**ARTHUR PHILLIP HIGH SCHOOL
AND
PARRAMATTA PUBLIC SCHOOL**

ACCESS REVIEW

SCHEMATIC DESIGN (AC-SD-03)

21st March 2016

1 HERITAGE B - DEMO - GROUND
1:100

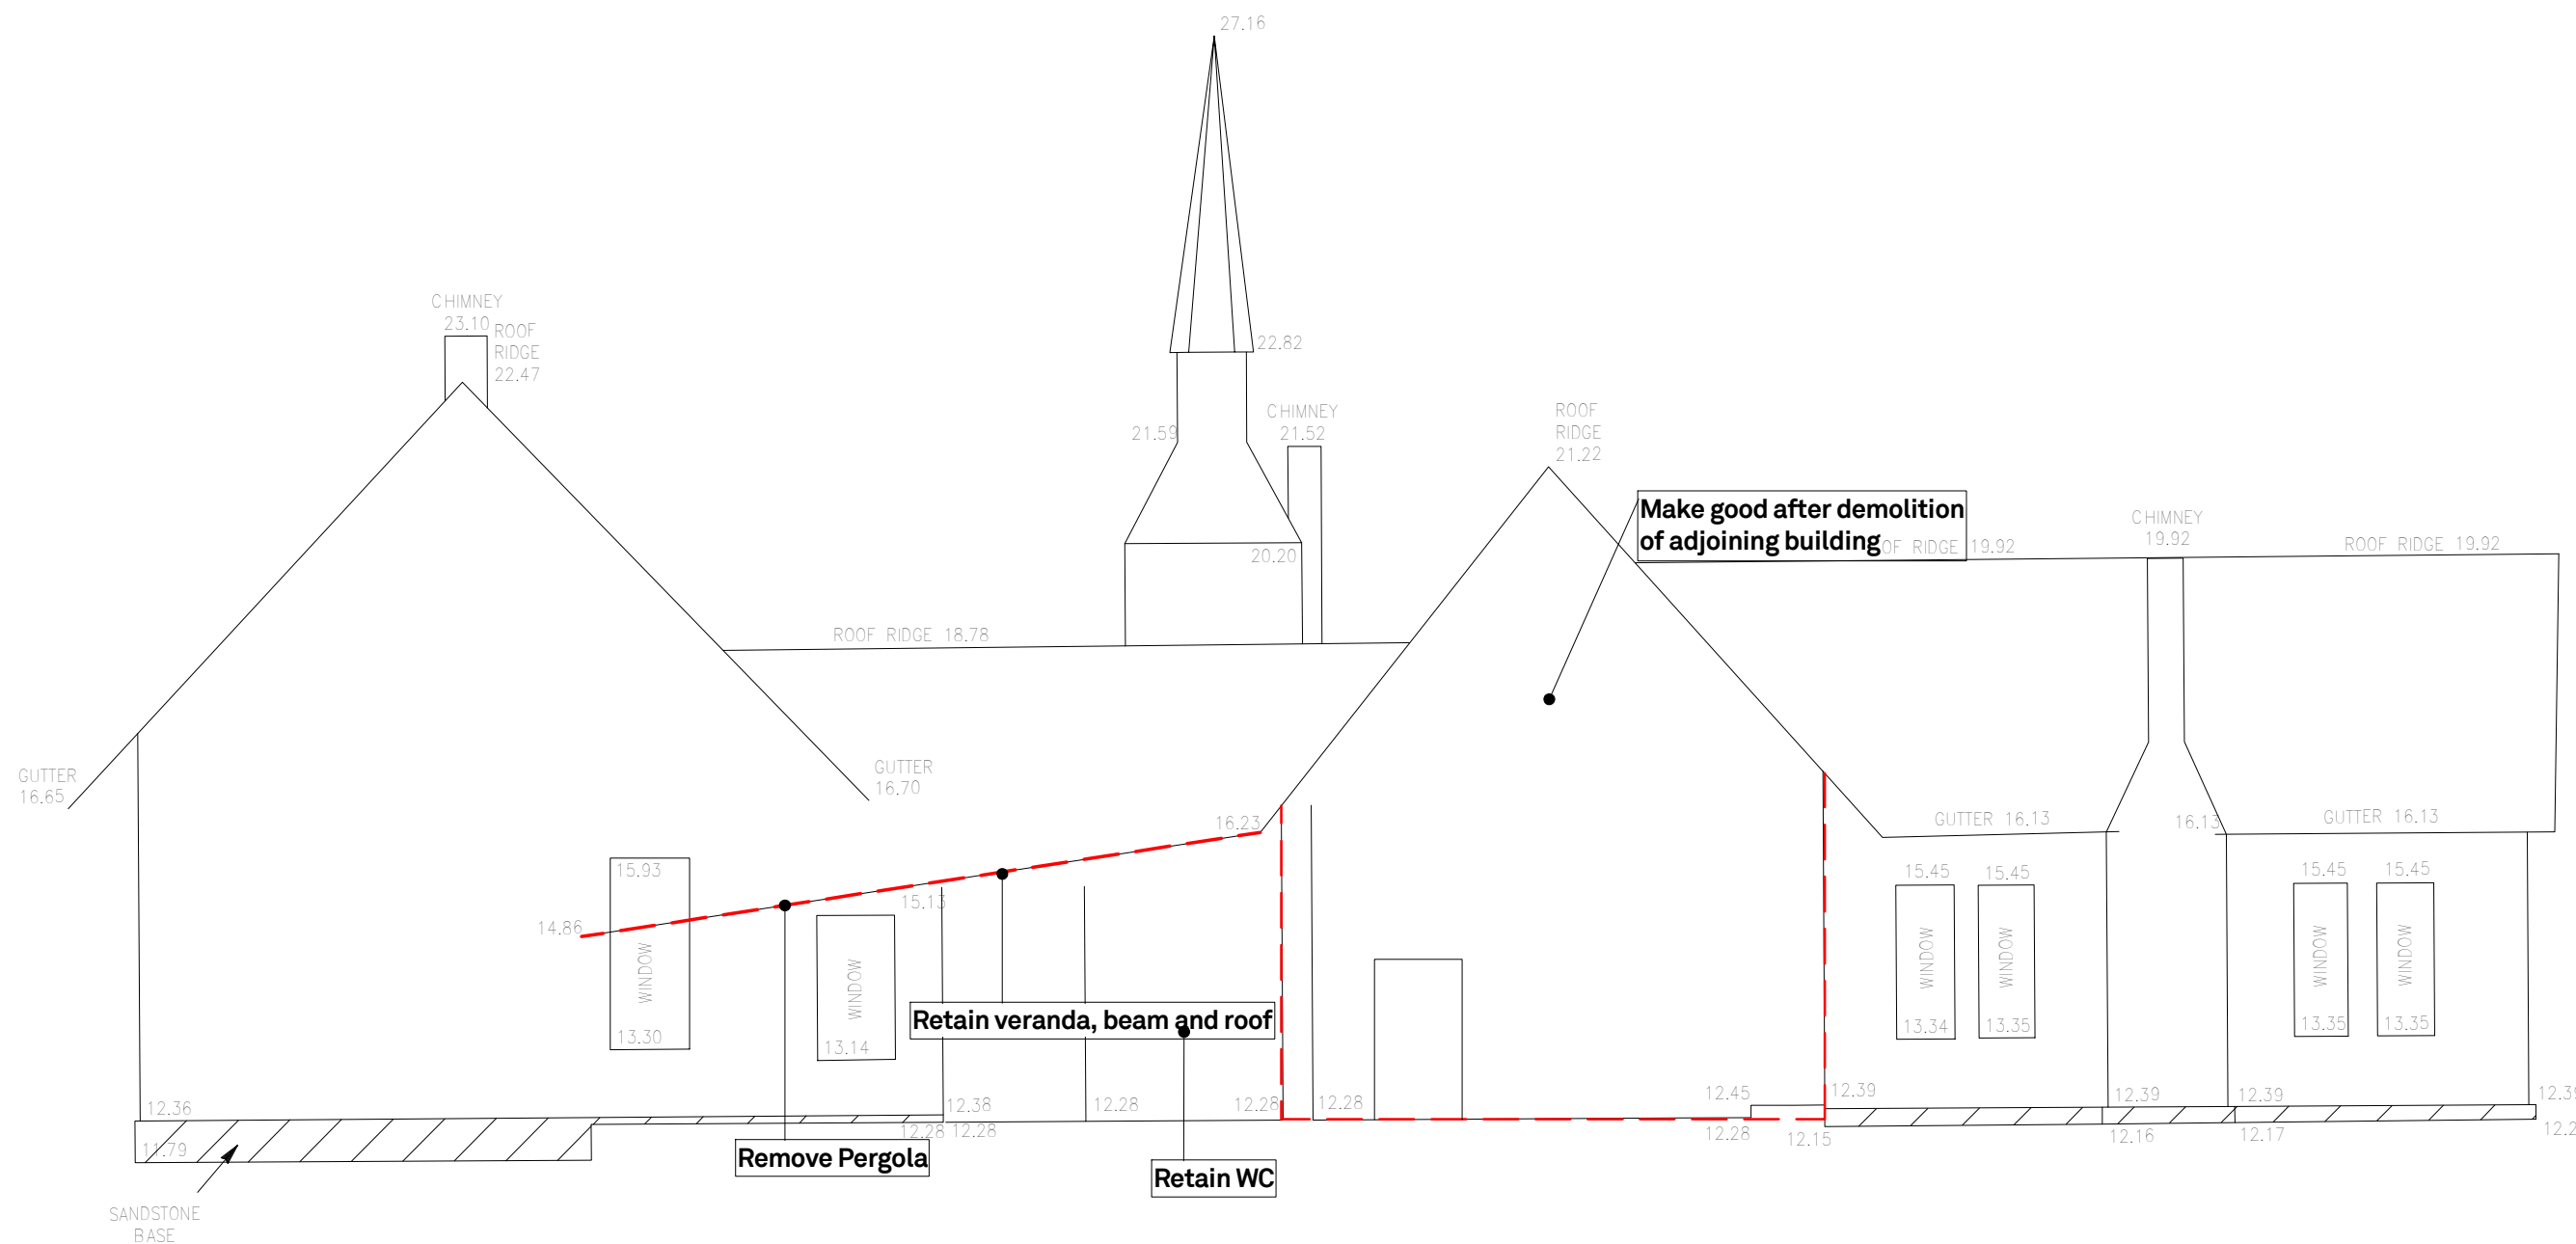
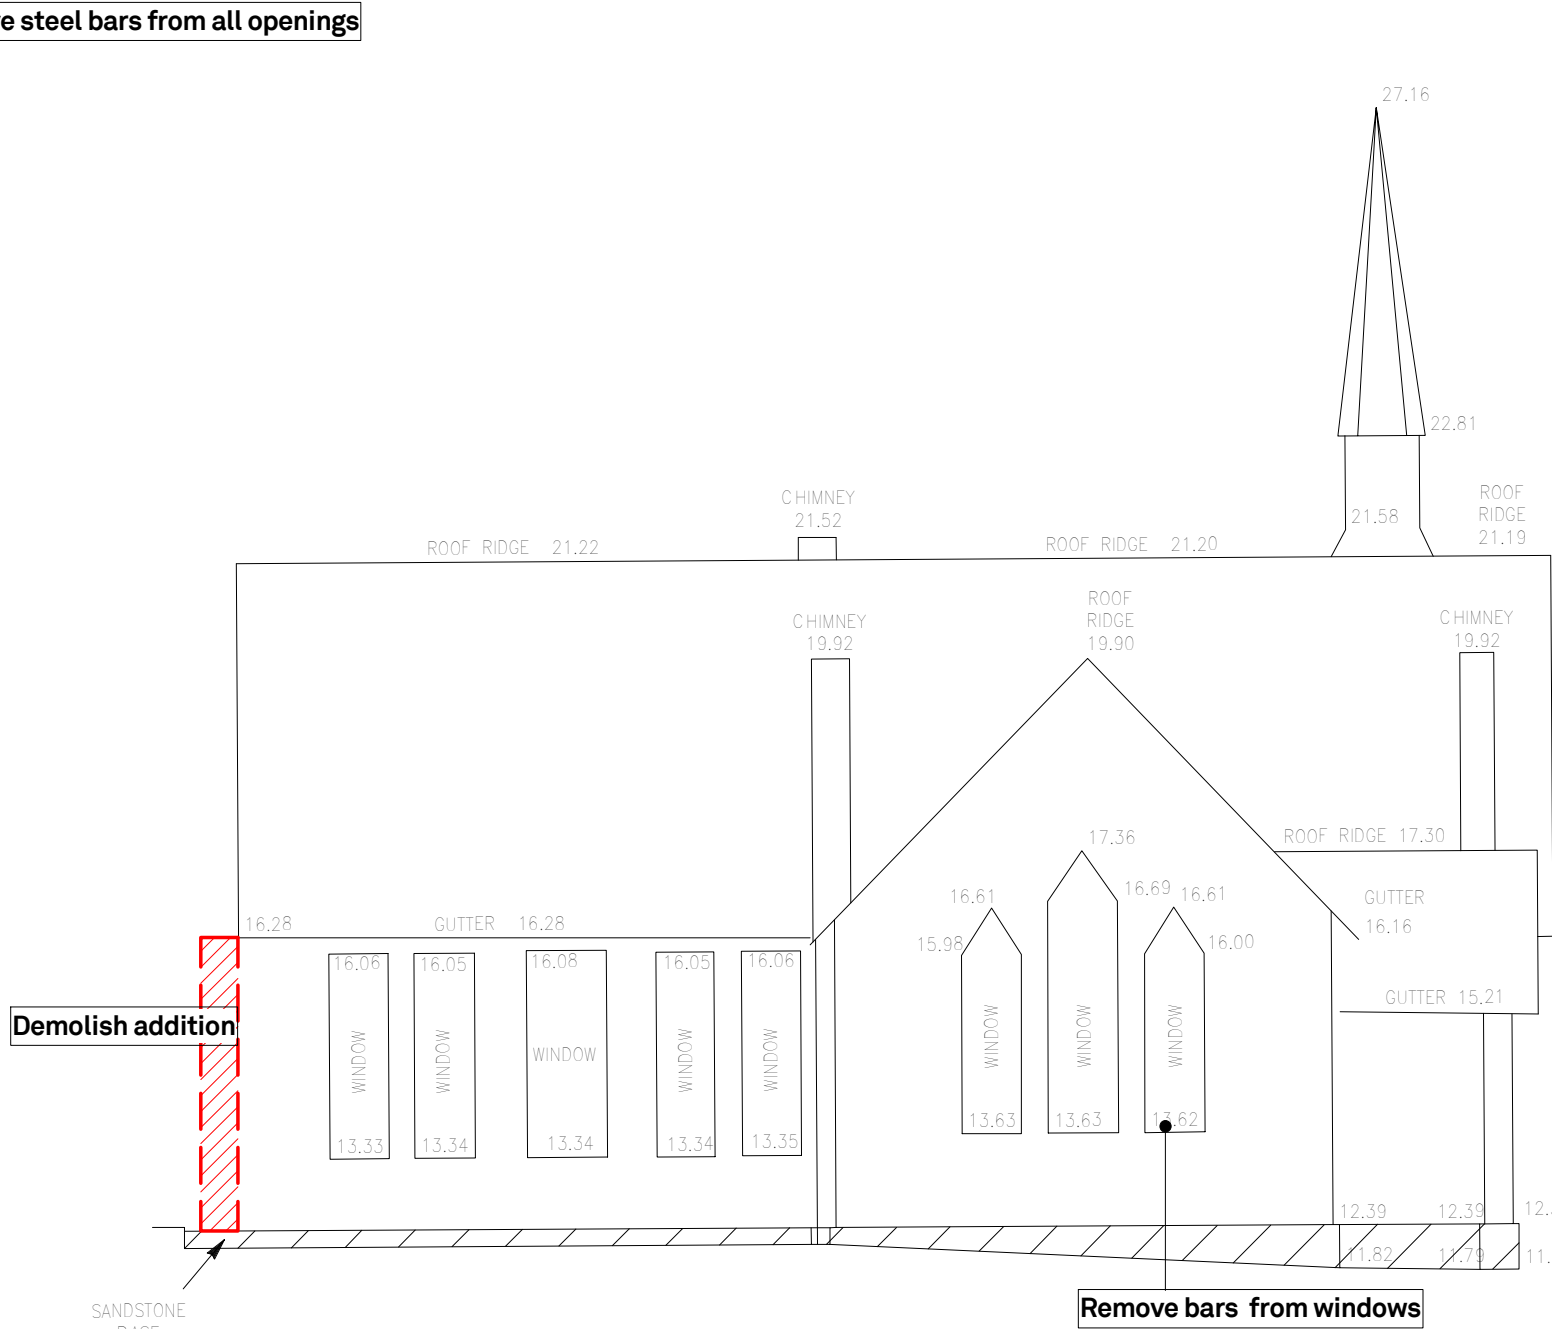
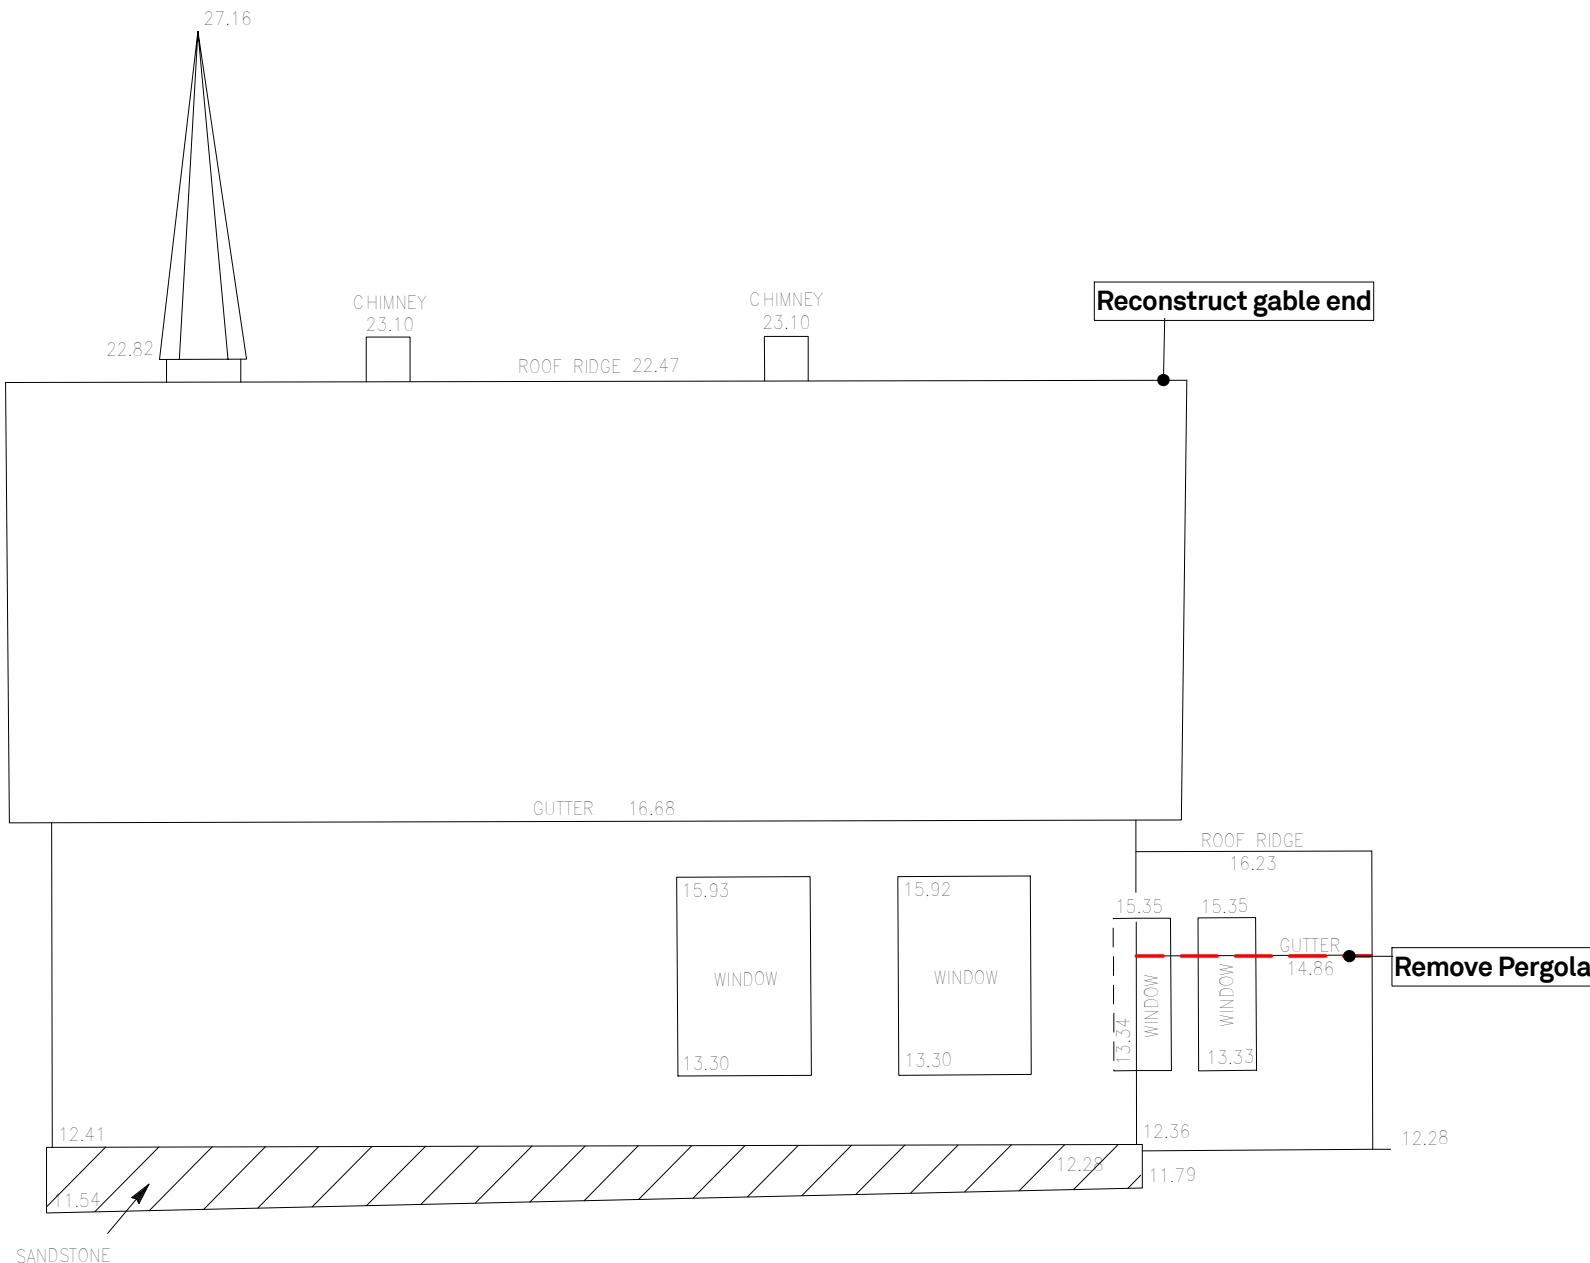
There are two levels of administration and staff rooms located in the existing Heritage Building. From the information provided there are a set of double doors to the entry. Review is required to either automate the pair of doors or to provide as a minimum 1 leaf achieving 850mm clear opening width.

On Level 2 there is a walkway connecting the Learning areas to the Heritage Building. Review is required to provide a compliant ramp and landing of 1540 x 2070mm outside the Heritage Building door, compliant with AS1428.1:2009.

- (i) At the Level 2 entrance to the Heritage building, provide a 1540 x 2070mm landing between the entry door and top of ramp, compliant with AS1428.1:2009.
